Comment for March 27 MMC Expansion Meeting

Jenny MacKenzie <gabeat@msn.com> Posted in group: Planning Board Mar 27, 2018 1:17 PM

I have concerns about the closing of Congress Street during Phase I expansion of MMC and have the following suggestions -

Congress Street Detour

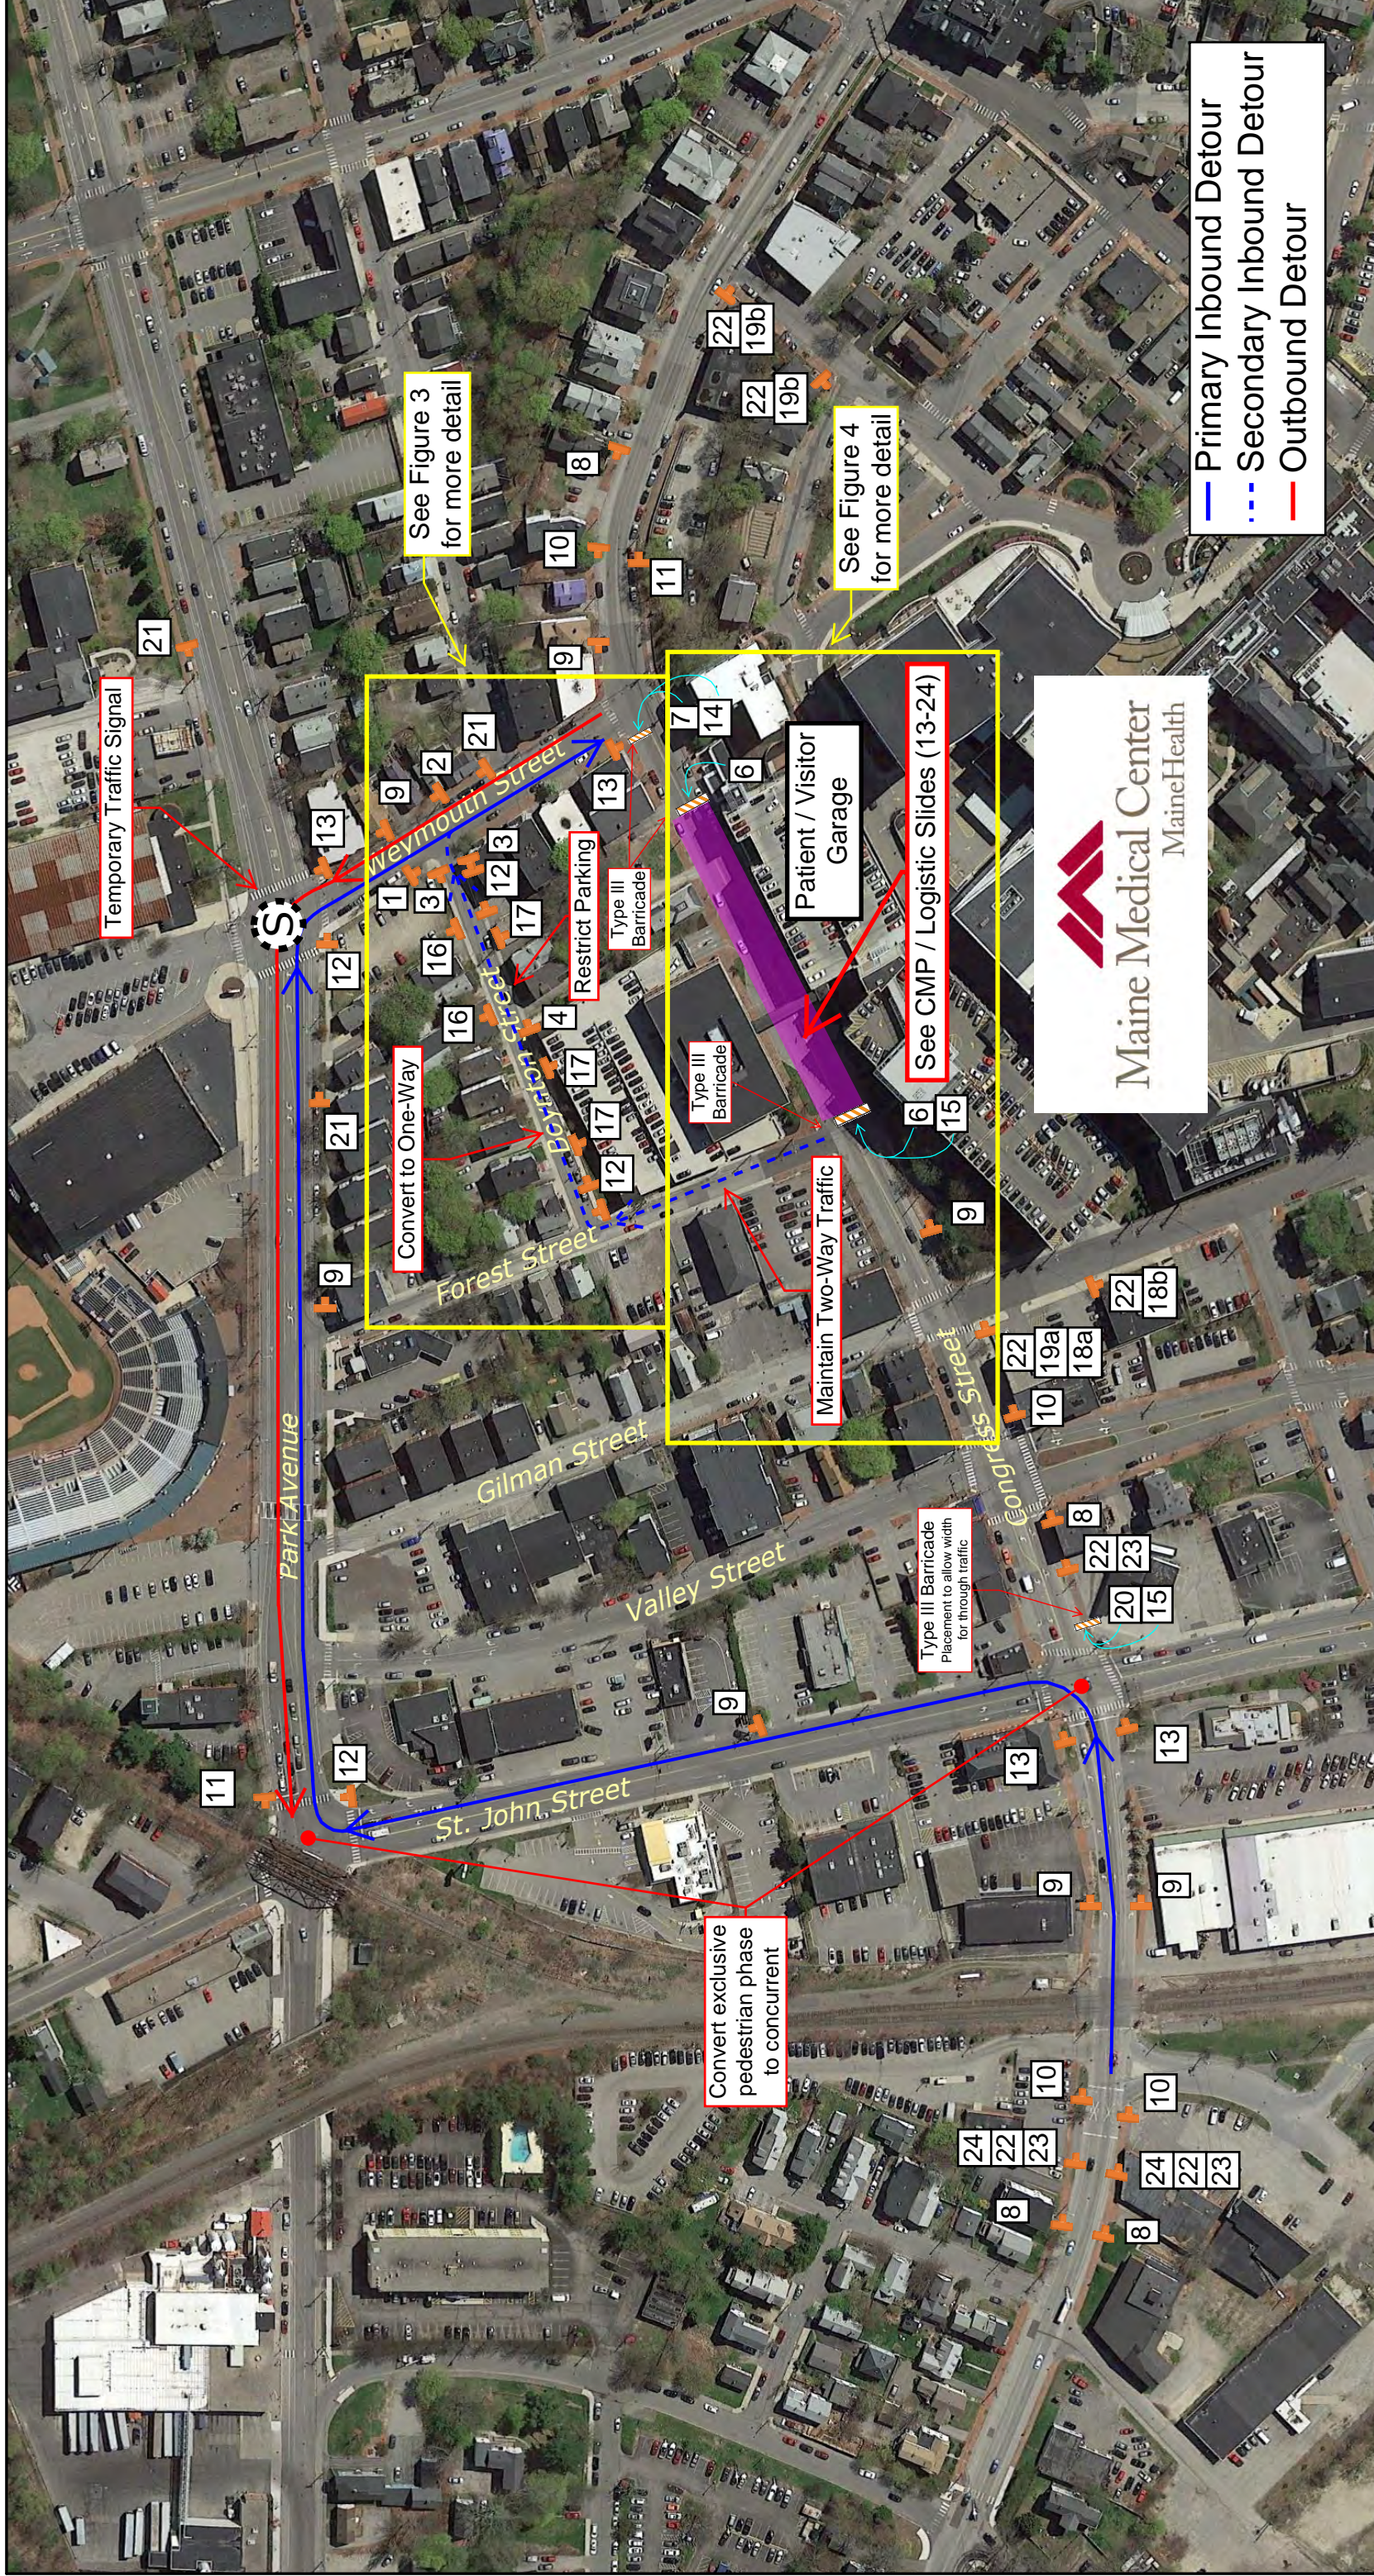
- Traffic be alerted by flashing signage on 295, in the vicinity of Exit 4 or 5 that an alternate route should be sought (suggest taking Exit 4 or Exit 6).
- Traffic coming off the Veteran's Bridge should be directed towards St. John Street or Fore River Parkway (concern about increased traffic on Valley). Another flashing sign would be helpful here.
- Traffic coming in-town via outer Congress and Exit 5 should be diverted to Park Street via St. John Street. I would like to see "Local Traffic Only" signs at the corner of Valley/Congress and Gilman/Congress to prevent excessive traffic from filtering down Forest and Boynton Streets.
- Increased monitoring of on-street parking violations during Sea Dogs games.
- Suspension of the weekly overnight parking restrictions in the surrounding streets (St. John, Valley, A, C, D, Gilman, Boynton, Weymouth, Forest, Park, etc.)
